September 28, 2022

Reference: New Mexico Proton Advanced Cancer Therapy (NMPACT)
Response to Development Review Board Planning – Case Comments
Project: PR-2022-007588
Application: SI-2022-01658

LANDSCAPE - LANDSCAPE PLAN

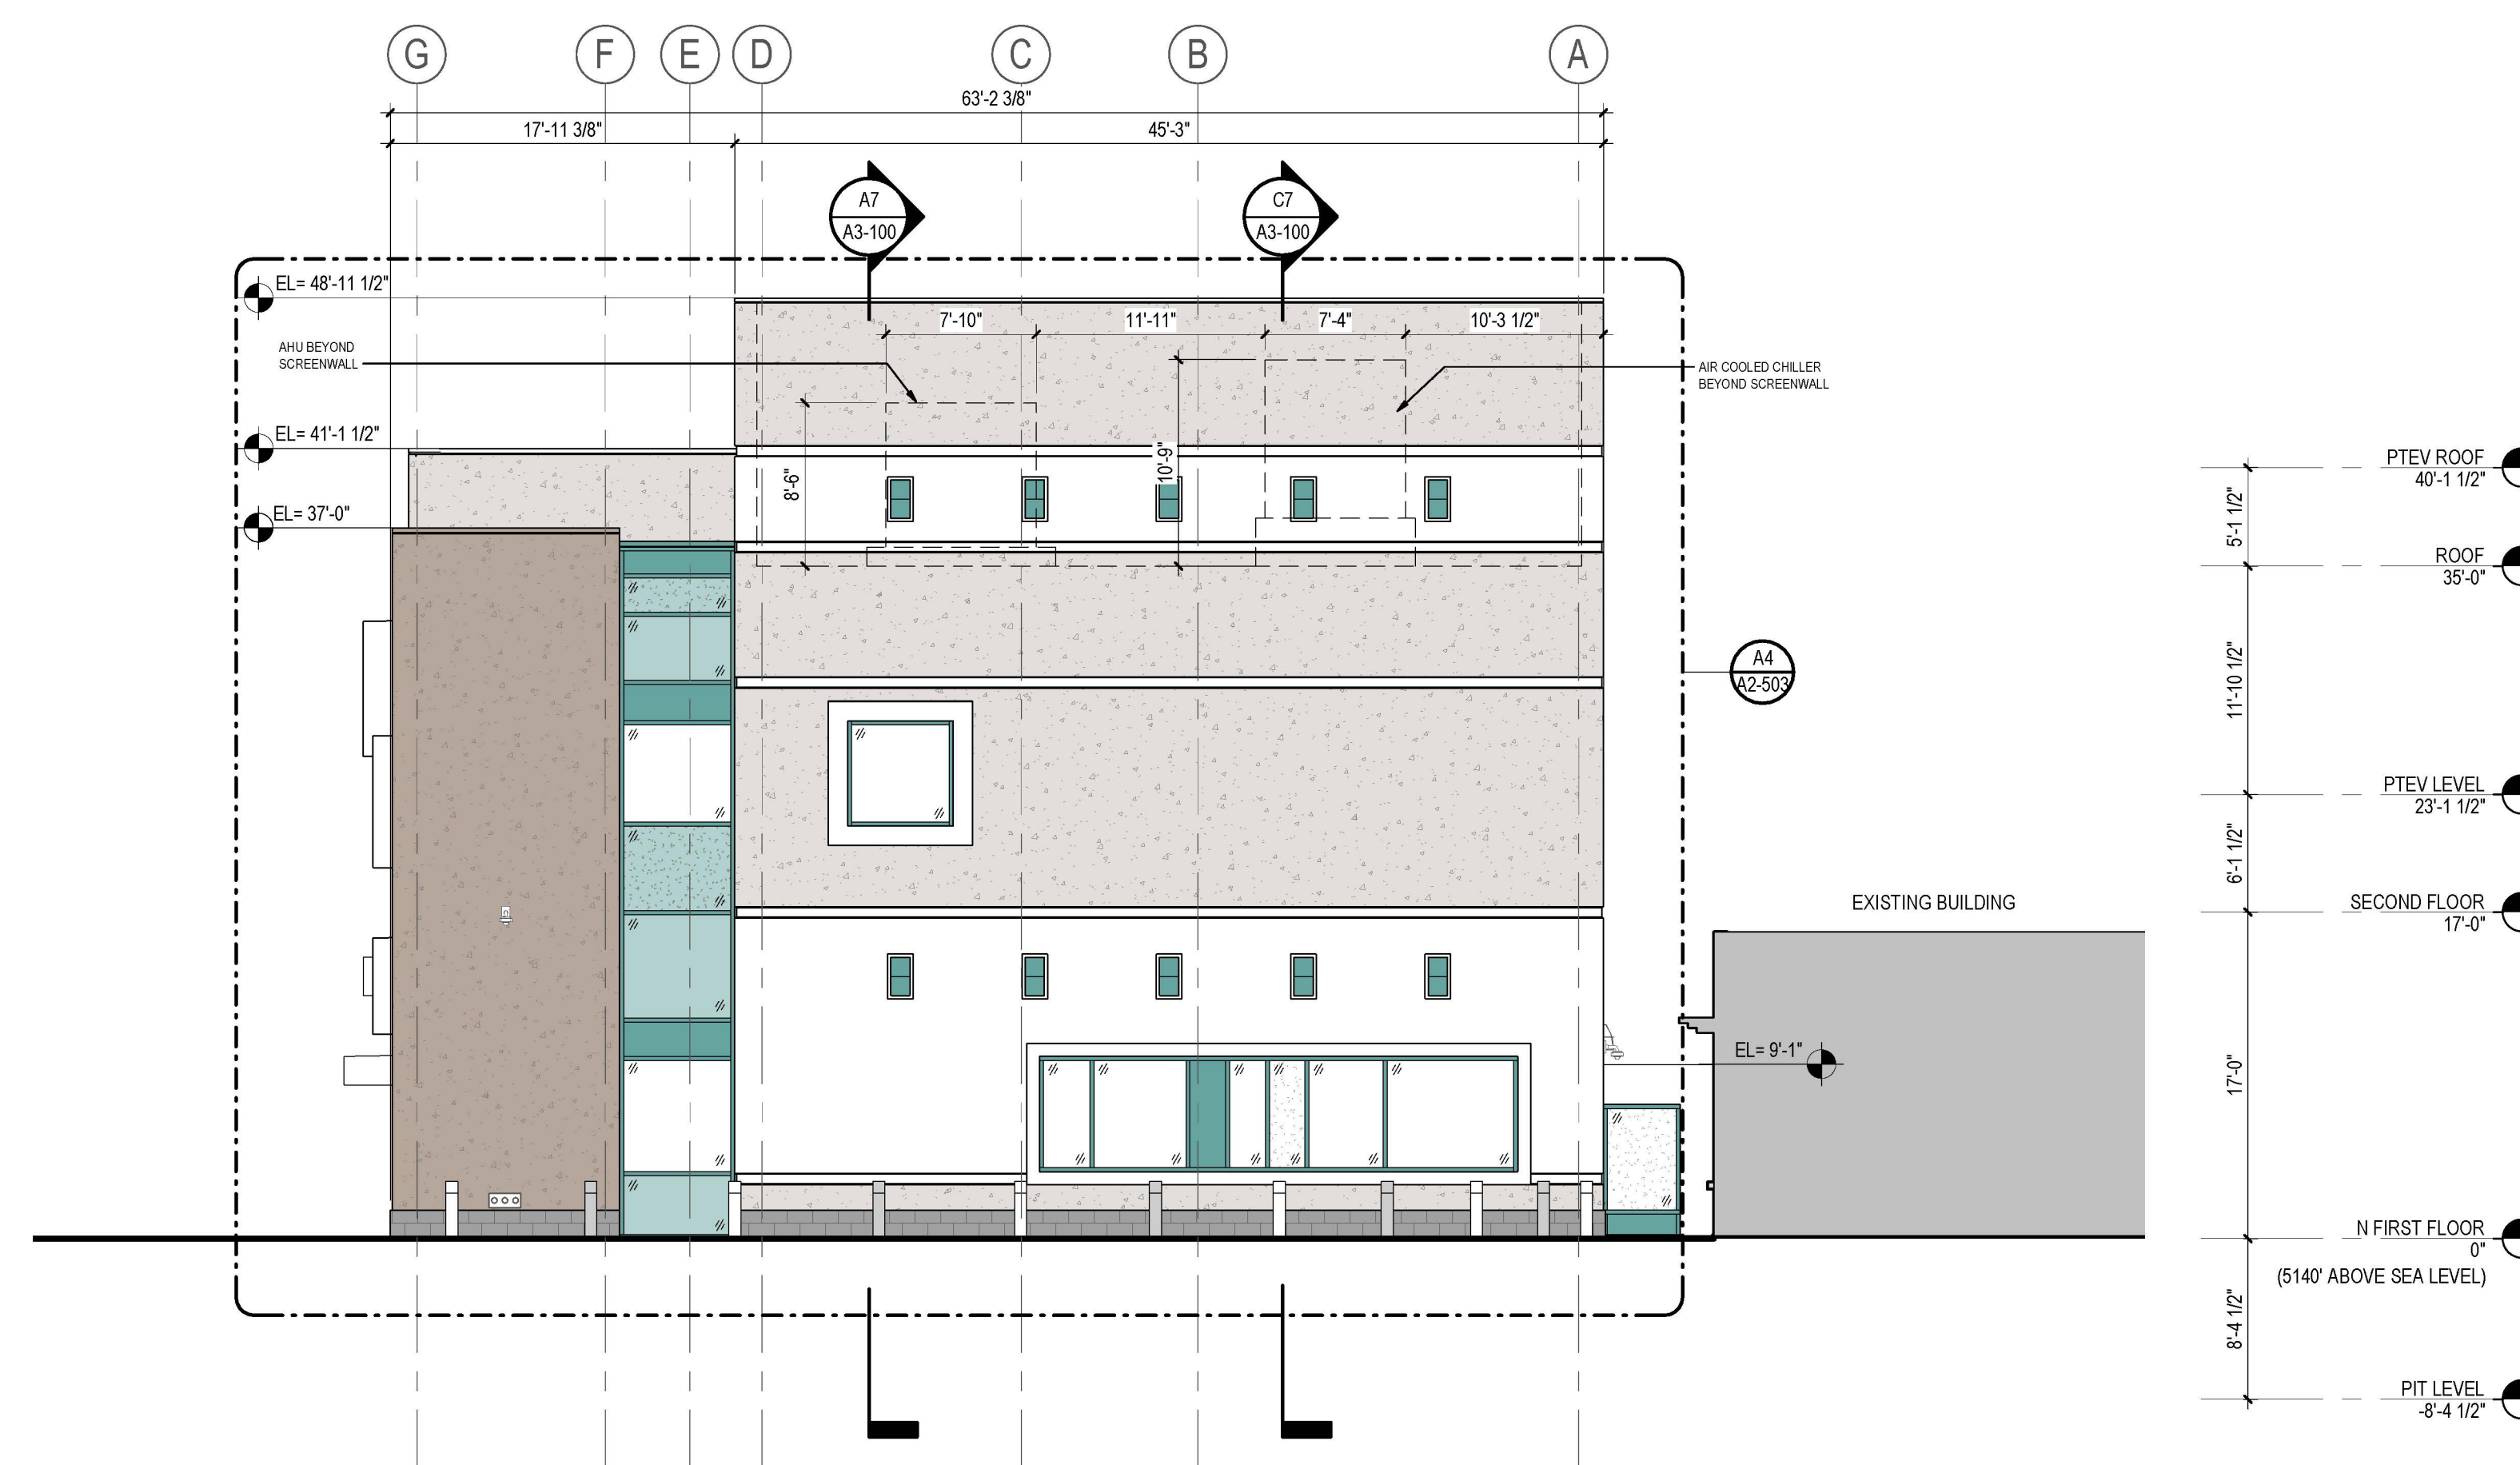
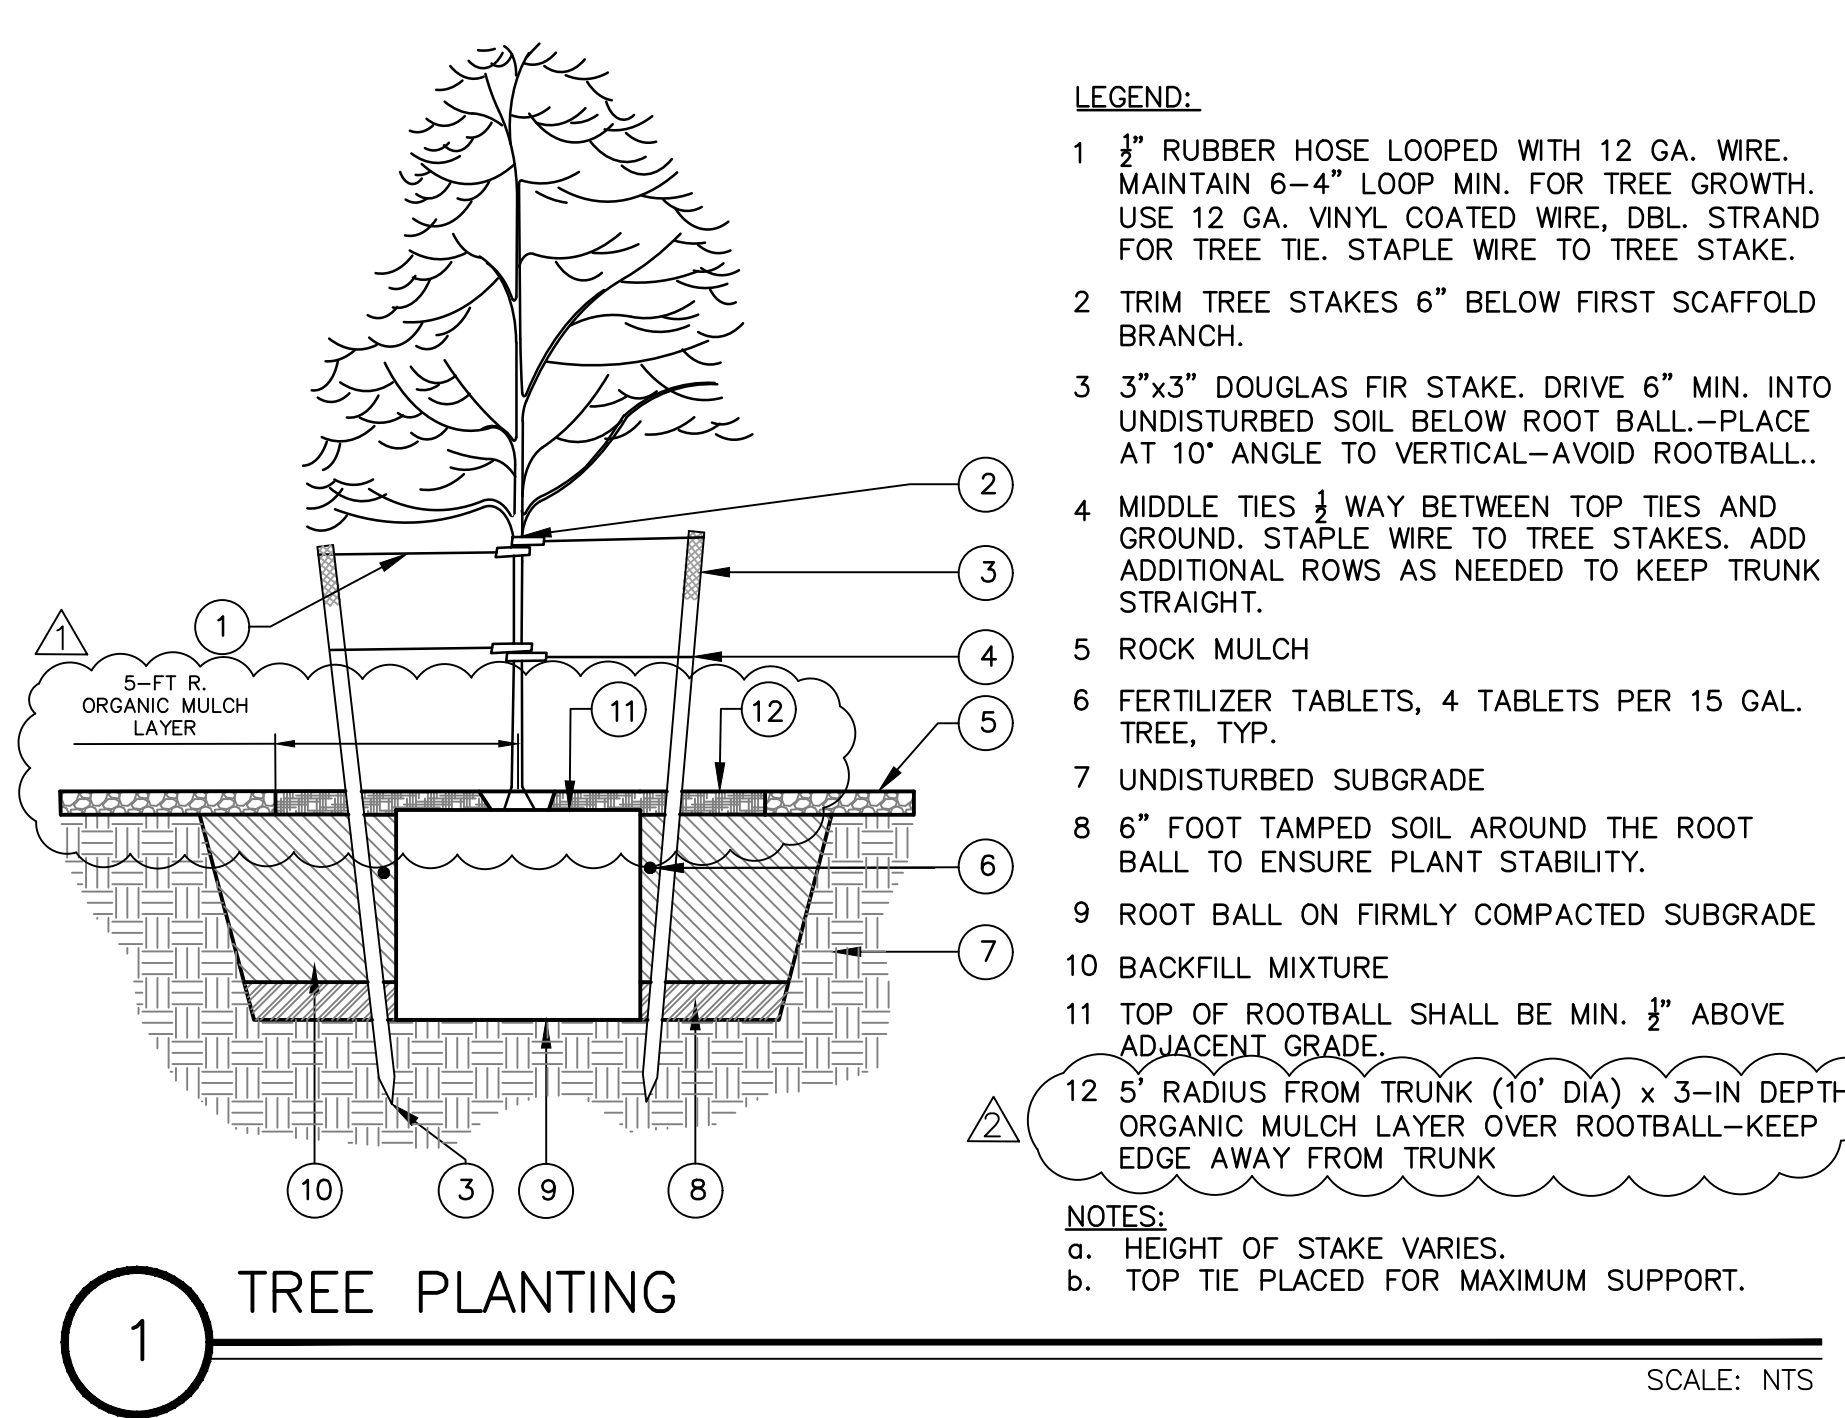
- a. *Stantec Response: Sheet C-101, Site Plan will be updated with the required information and resubmitted.*
10. The Landscape Plan must meet the 15% net lot area landscaping requirement per 5-6(C)(2) of the IDOS. Confirmation and calculations of this requirement must be provided on the Landscape Plan. (The plan sheet seems to state that the fire lane makes this requirement non-applicable, however staff is not able to confirm this per the IDO.)

11. The Landscape Plan depicts the removal of two large Chinese Pistache trees from the parking area. Staff discourages the removal of mature trees from a development if there is a way to save them. Please explain and justify their removal.

- a. *Stantec Response: The project removes 2,900 SF of landscape planter and installs 2,930 SF of new landscape planter; a 30 SF increase. The site improvement area is 22,200 SF and the landscape planter area (@ 2,930 SF) is 13.2%. To achieve 15% would require elimination of more parking which is already a challenge for the project. We request exemption from this requirement because the project is only a small building addition with minor site adjustments.*

- a. *Stantec Response: The existing, mature Pistache trees are removed because they will be negatively impacted by construction of new fire lane improvements. In our experience they would not survive trenching and installation of new curbing because its within their critical root zone (5-10 feet of their trunks). Additionally, construction of the new parking lot will recompact the soil - creating oxygen deprivation. We propose new trees in new planter conditions as the surest approach to providing healthy plants.*
